**Outer Dowsing Offshore Wind (the trading name of GT R4 Limited)  
("ODOW")**

**Proposed Outer Dowsing Offshore Wind Farm Order (the "Project" and  
"the Order")**

**Written Representation (Objection) on behalf of T.H. Clements & Son  
Limited ("T.H. Clements")**

Environmental Statement
 Weston Marsh Initial Onshore
 Export Cable Corridor Options
 Figure 4.20

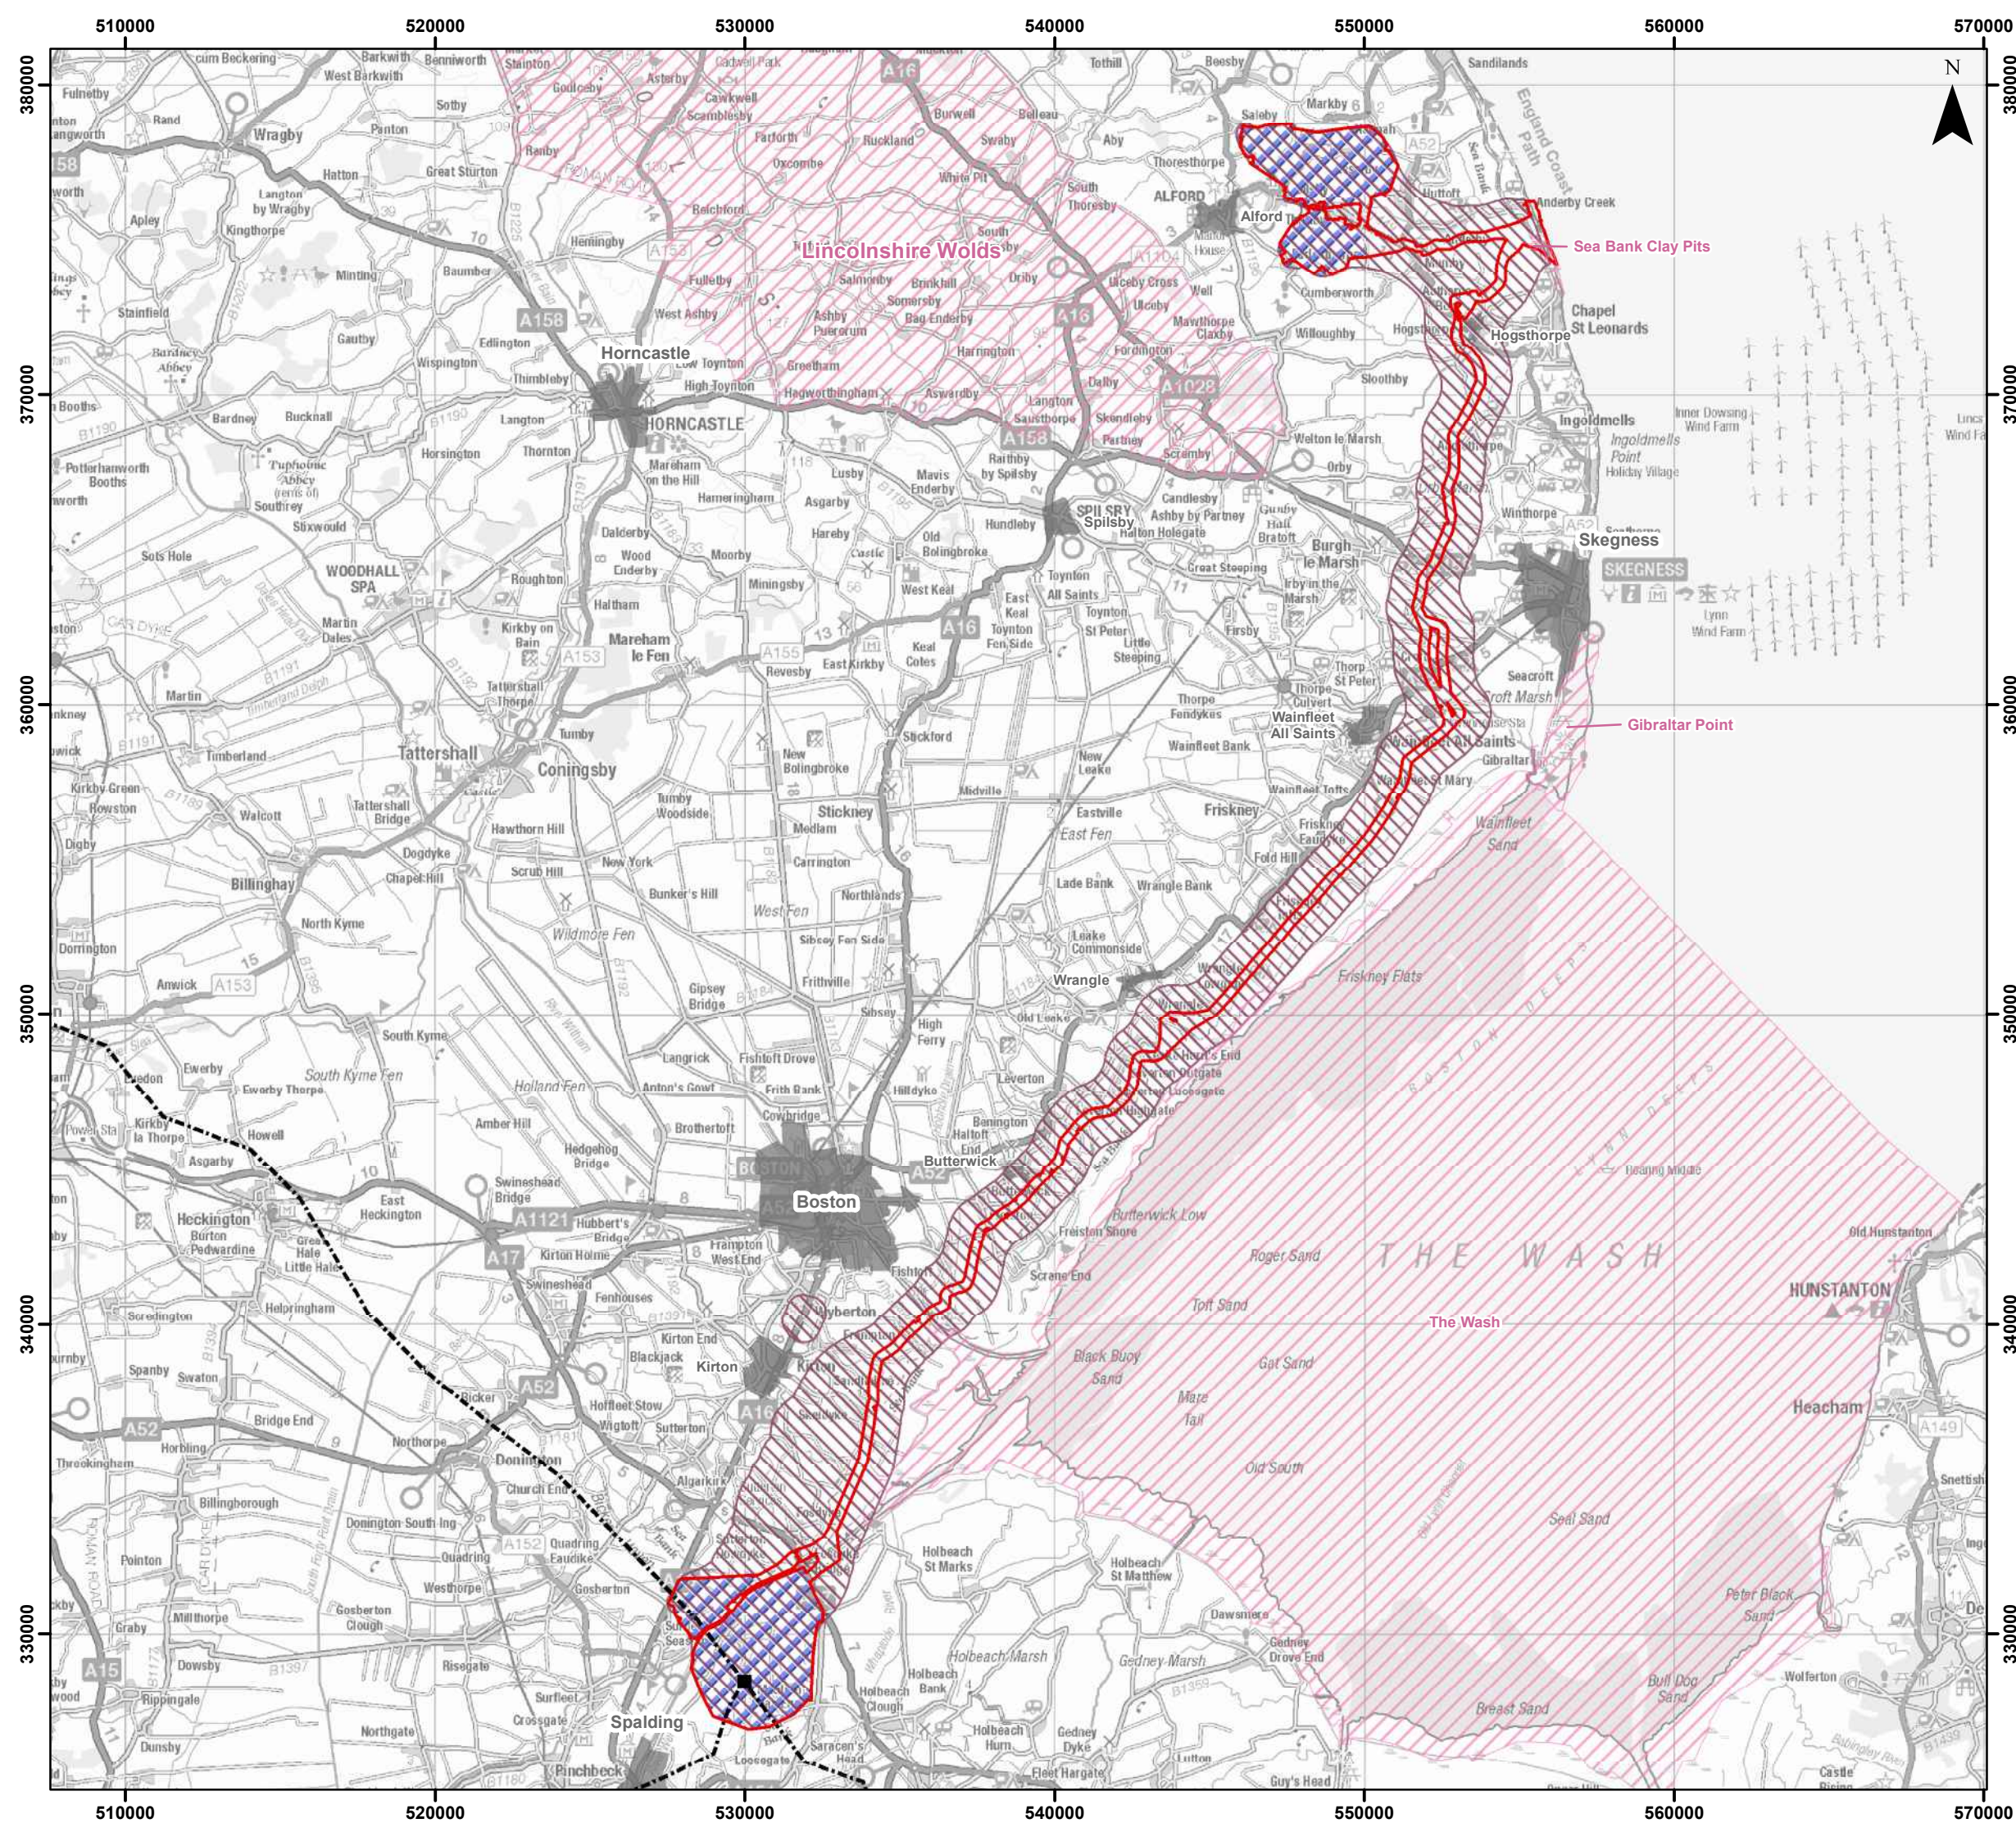
- 4.1.3 The first option ('Option 1', indicated by a blue line on Figure 4.20) originates at the landfall location at Wolla Bank, south of Anderby Creek, and follows a southerly direction, to the east of Burgh Le Marsh and Wainfleet All Saints, before crossing agricultural land to the south of the A52. The ECC then passes to the south of Boston, crossing the Haven, River Welland and A17. This appears to be the 'Wolla Bank-Weston Marsh' option in Table 4B.1 of Annex A.

- 4.1.4 The second option ('Option 2', indicated by a purple line on Figure 4.20) originates from the landfall point north of Anderby Creek and takes a more northerly direction to the northwest of Burgh Le Marsh. The ECC then runs parallel to the Boston to Friskney rail line before passing around the north of Boston, and circumnavigating the town in an anticlockwise direction. This option then joins the ECC of Option 1 to the north of Fosdyke. This appears to be the 'Boston Northern Option' in Table 4B.1 of Annex A.

- 4.1.5 The third option ('Option 3', indicated by a green line on Figure 4.20) follows the same route as Option 2 until it reaches Spilsby, at which point the ECC turns southeast to circumnavigate Boston in a clockwise direction. This option runs to the west of the Hobhole Drain before joining the ECC of Option 1 to the north of Fishtoft. This appears to be the 'Boston Southern Option' in Table 4B.1 of Annex A.

- 4.1.8 Choosing Option 2 (the purple route) would significantly reduce the amount of Grade 1 ALC land affected by the Project, and the majority of the Grade 1 ALC land that would be affected by this alternative route does not comprise the very top-quality silty soils situated to the east of the A52 public highway.
